# CITY OF ALBUQUERQUE

**Re: D & B U-SELL-IT**  
**8531 Bluewater Rd. NW**  
**Traffic Circulation Layout**  
Engineer's Stamp 12-03-24 (K10-D066)

Based upon the information provided in your submittal received 01-08-24, the above referenced plan cannot be approved for Building Permit until the following comments are addressed:

BICYCLE RACK  
N.T.S.

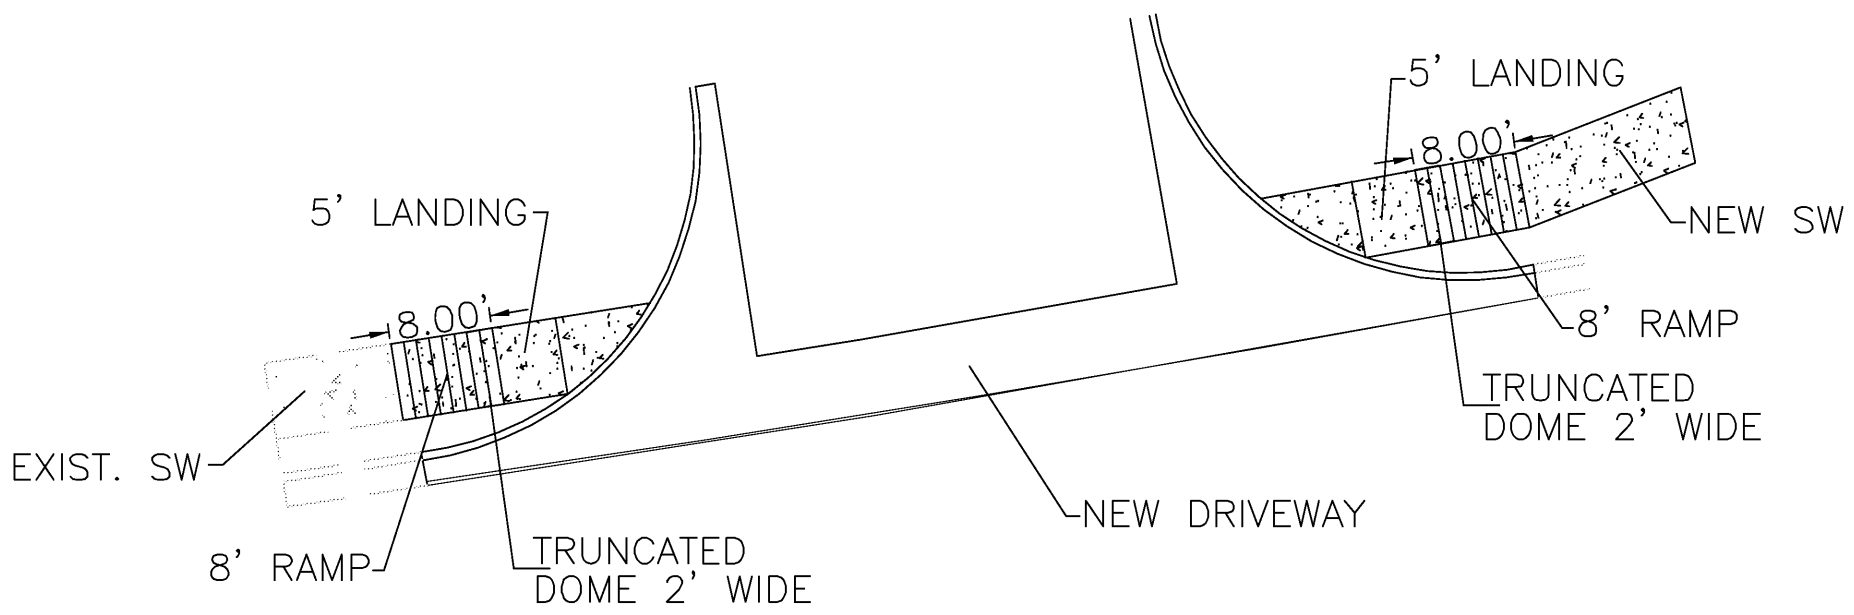
8. The pavement marking "MC" should be shown in the opposite direction for motorcycles entering the parking space.
9. Key note 11: Please provide Bike Rack details.

BLUEWATER DRIVEWAY W.C. RAMP DETAIL

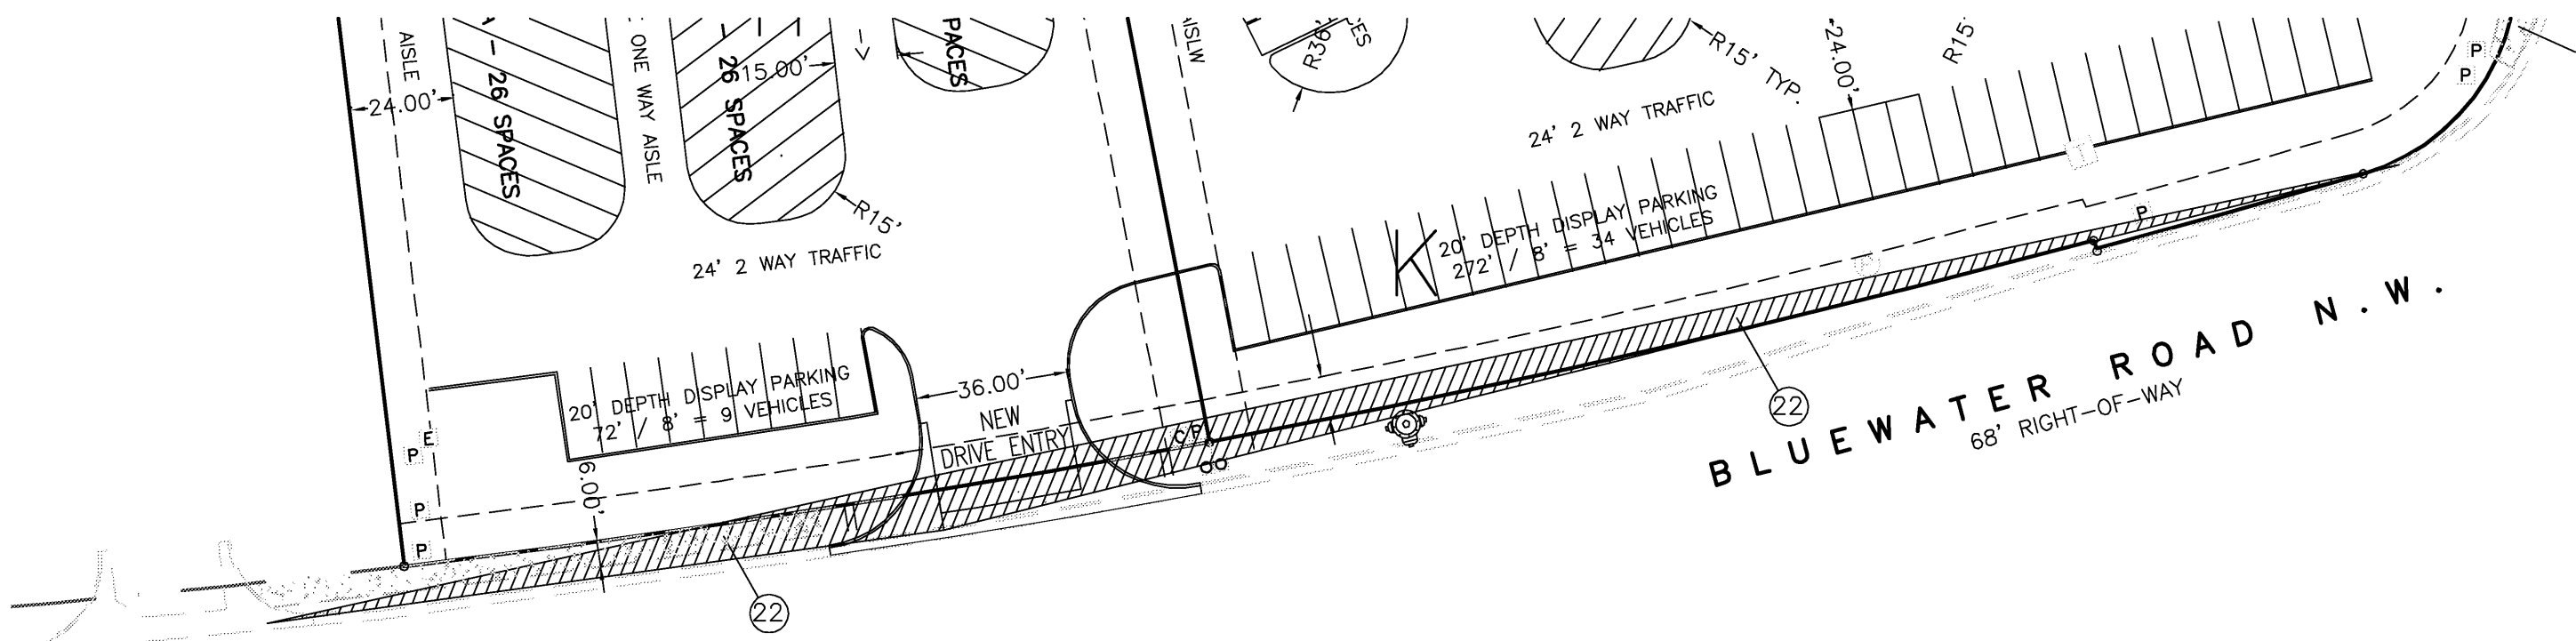
3. Site access off Bluewater Rd:
  - Show on the site plan the proposed site access width.
  - Key note 24: provide proposed ramps details. 2440 is a city standard for Curb Access ramp general notes.

CLEAR SIGHT TRIANGLE BLUEWATER

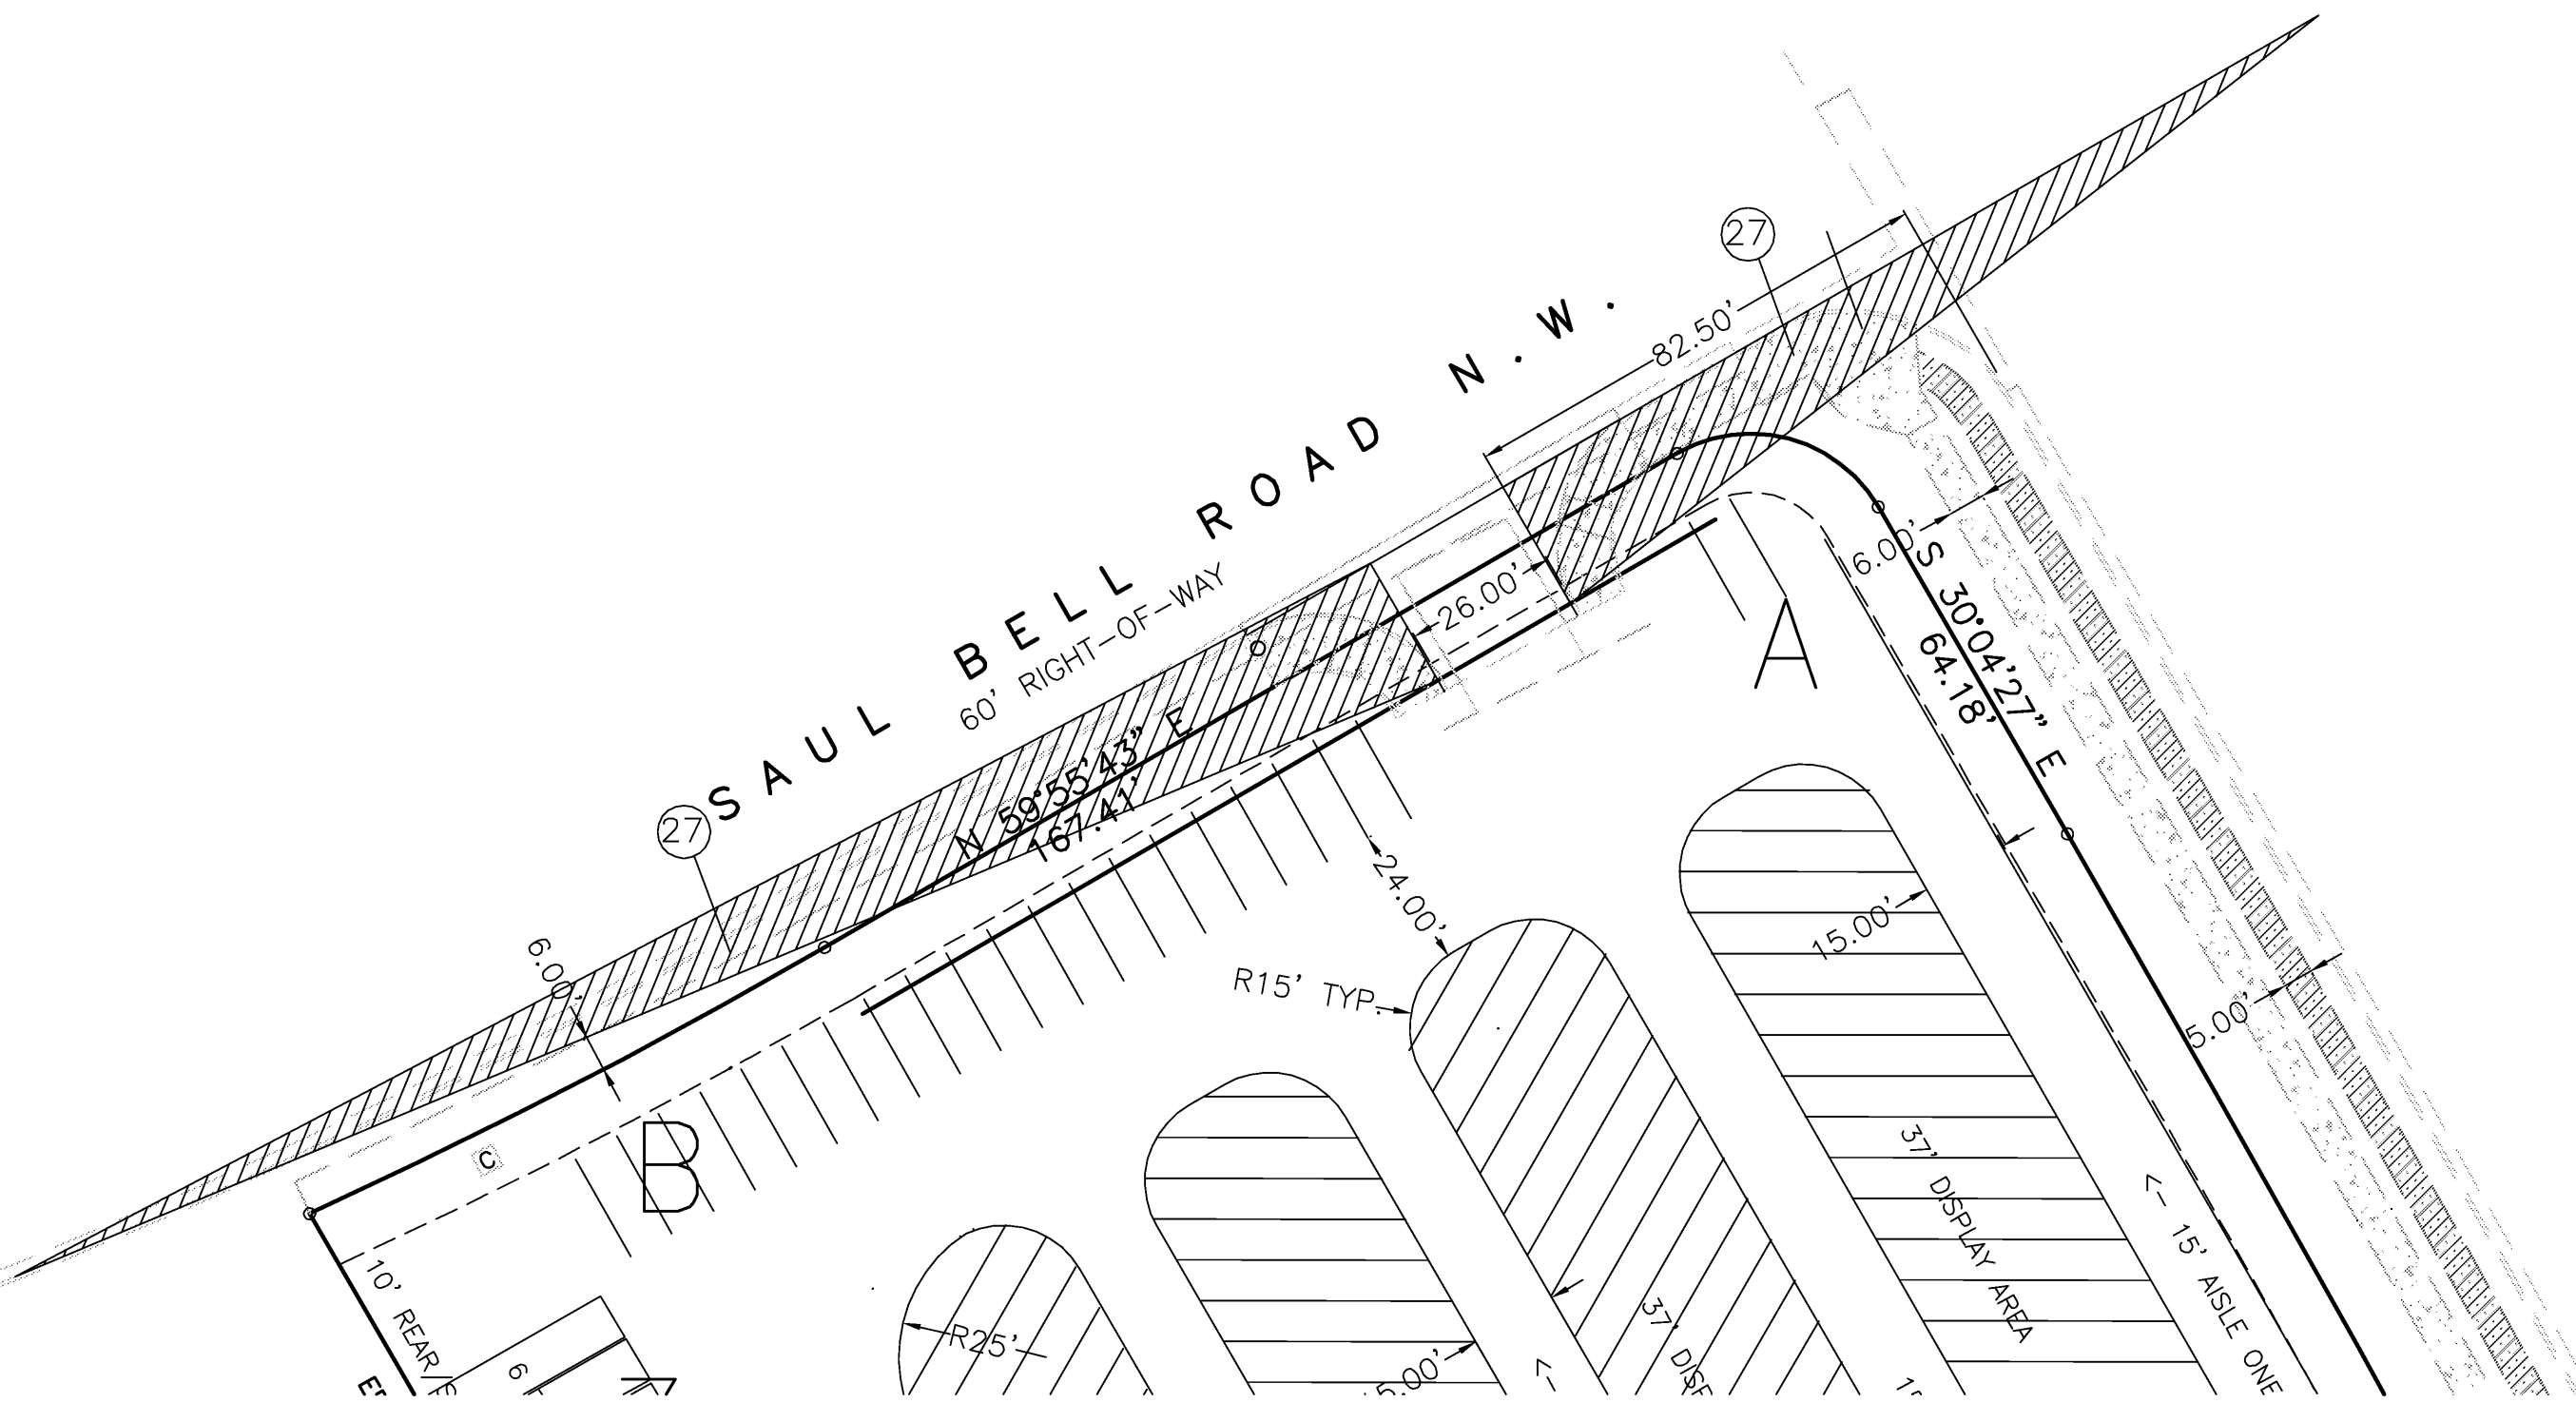
13. Show the clear site triangle on the site access off Saul Bell Rd.
14. Provide a copy of Fire Marshal and Solid Waste approval.
15. Work within the public right of way requires a work order with DRC approved plans.
